EP-22-0022\_2 Latigo Trails Filing 9 SF2136

Proposed: 39 single-family lots within 107 acres

FILING 9  
SEPTIC  
SUITABILITY  
MAP

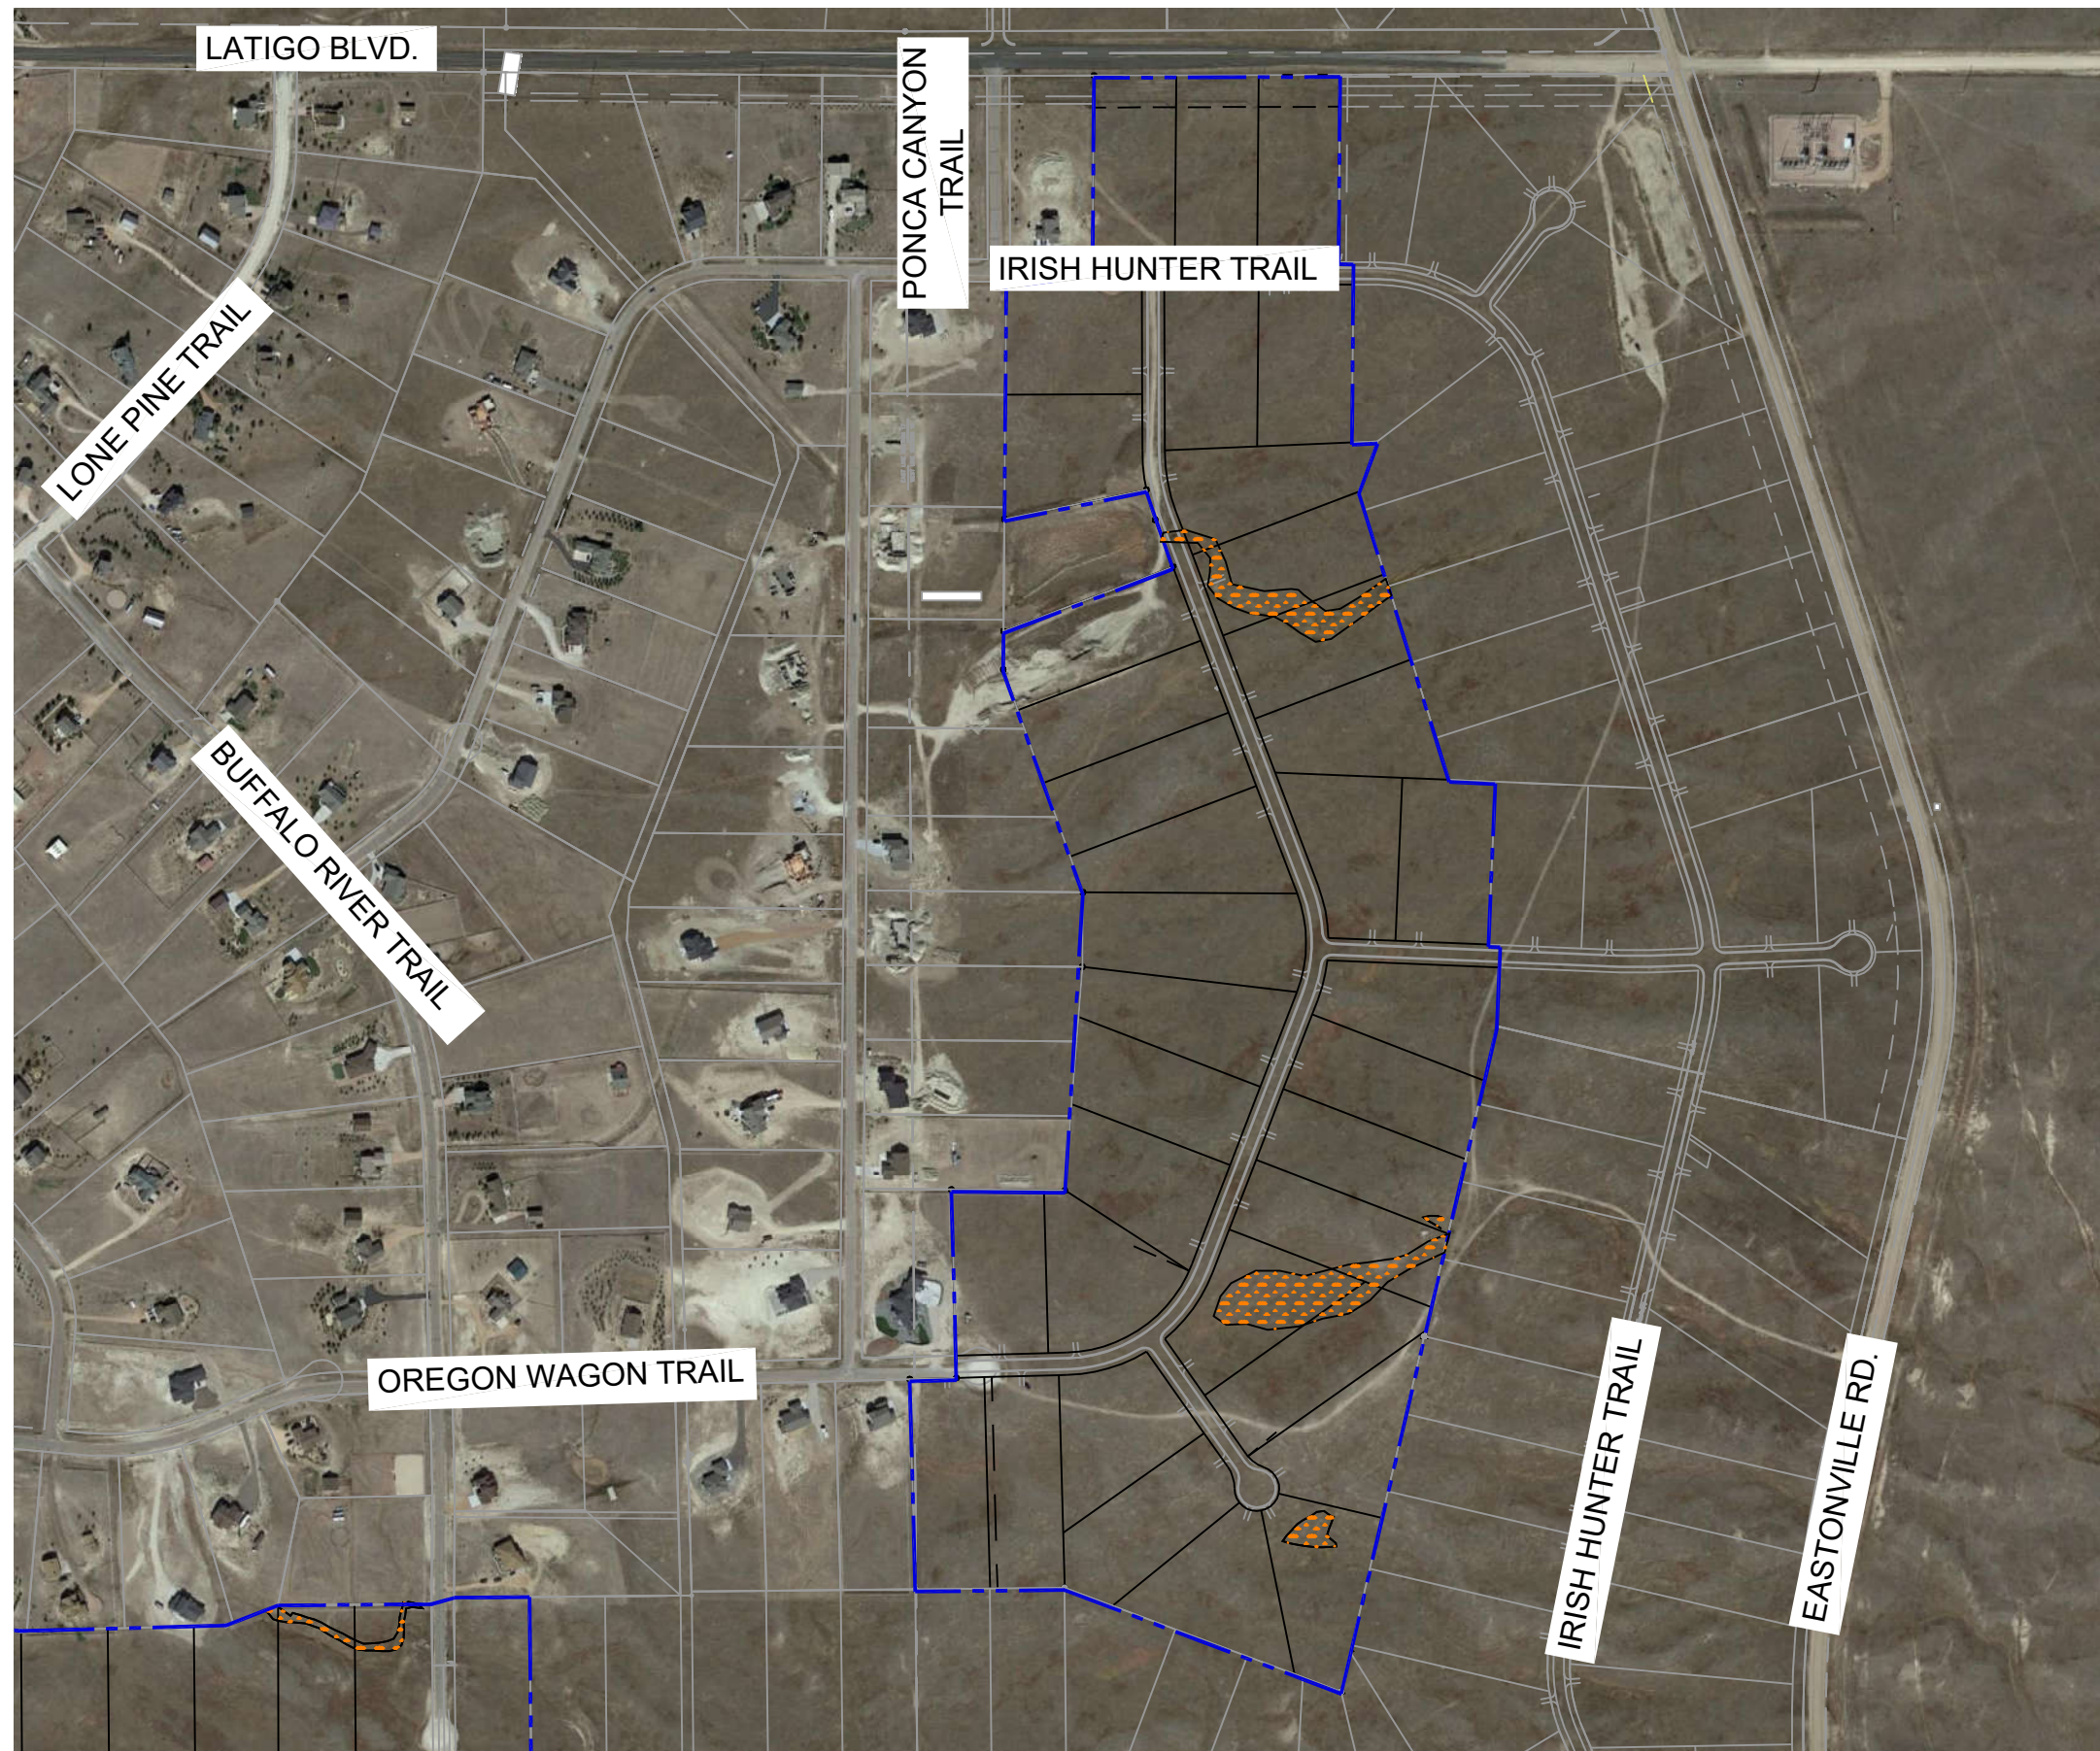
**Geotechnical Report.** Filings 9 and 10 in CTL's report are swapped; Filing 9 should be located on the southwest portion of the Latigo Trails development per the updated construction documents.
